From: Planning
Subject: FW: Consultation on planning application, 3/2021/0166, Lower Stony Bank, Wigglesworth Road, Slaidburn BB7 4TR

The application is for - Horse arena 30m x 40m for private use.

3/2021/0166

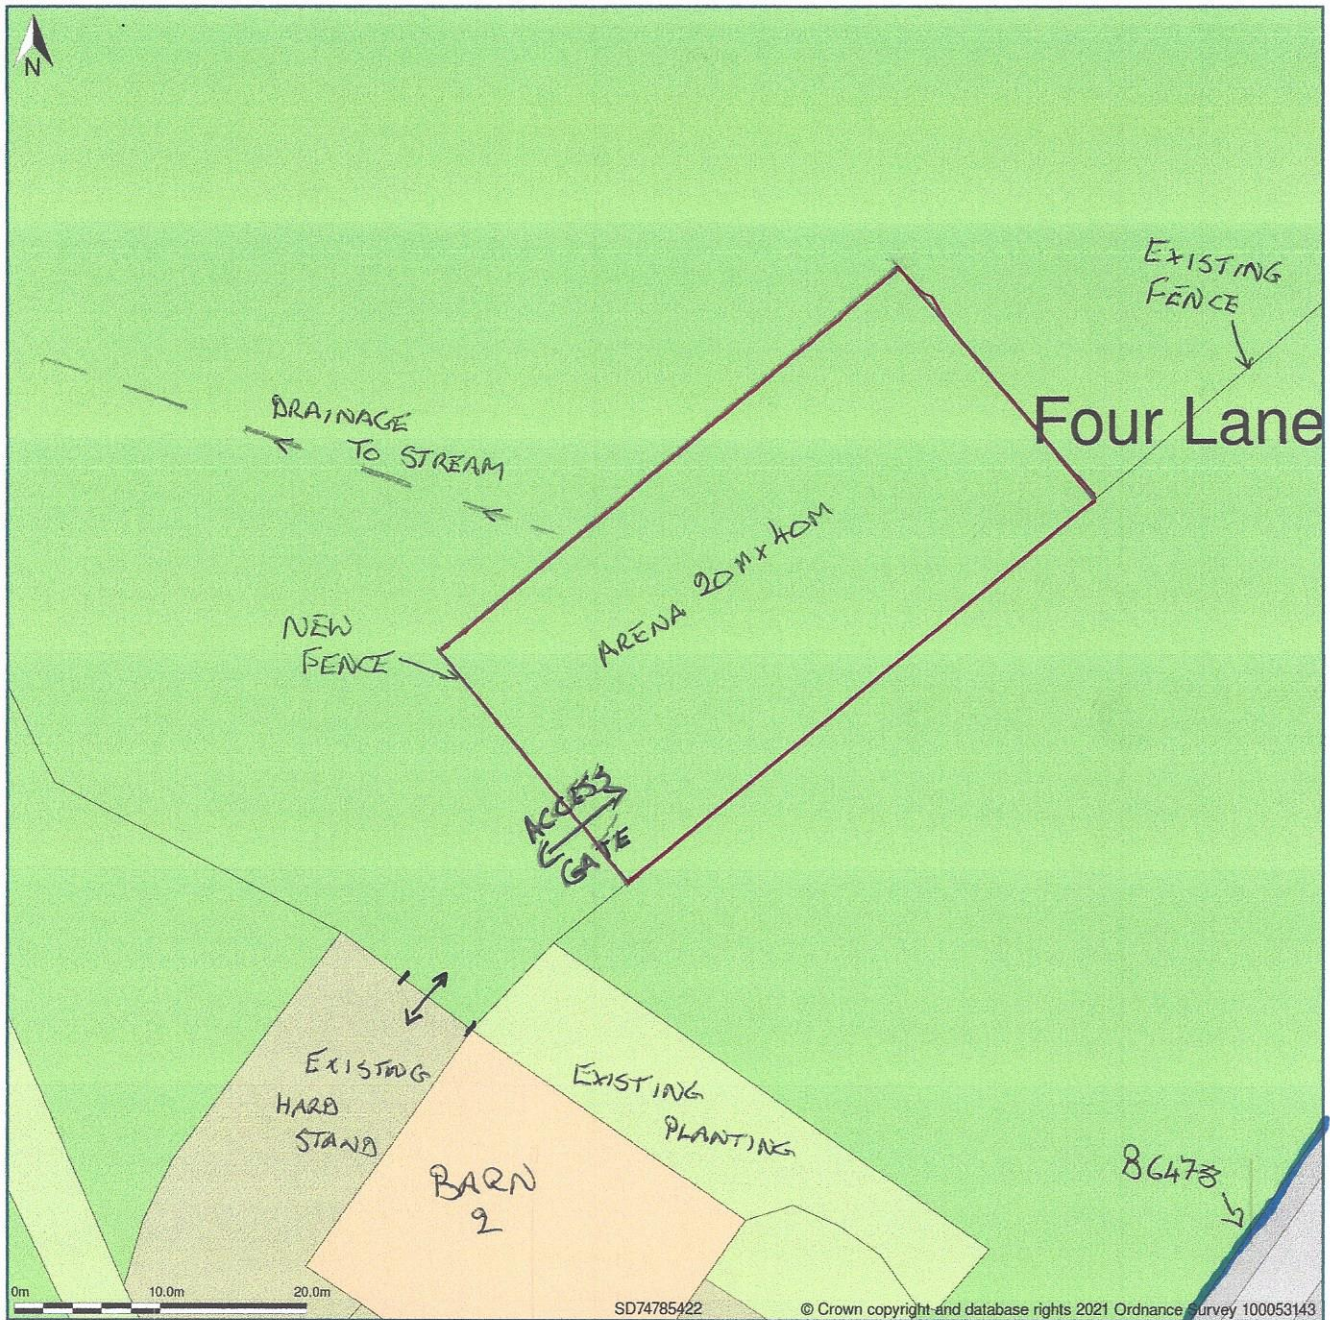
They are concerned about the location of the horse arena and wonder if it would be better placed nearer the existing buildings, due to the area being AONB.
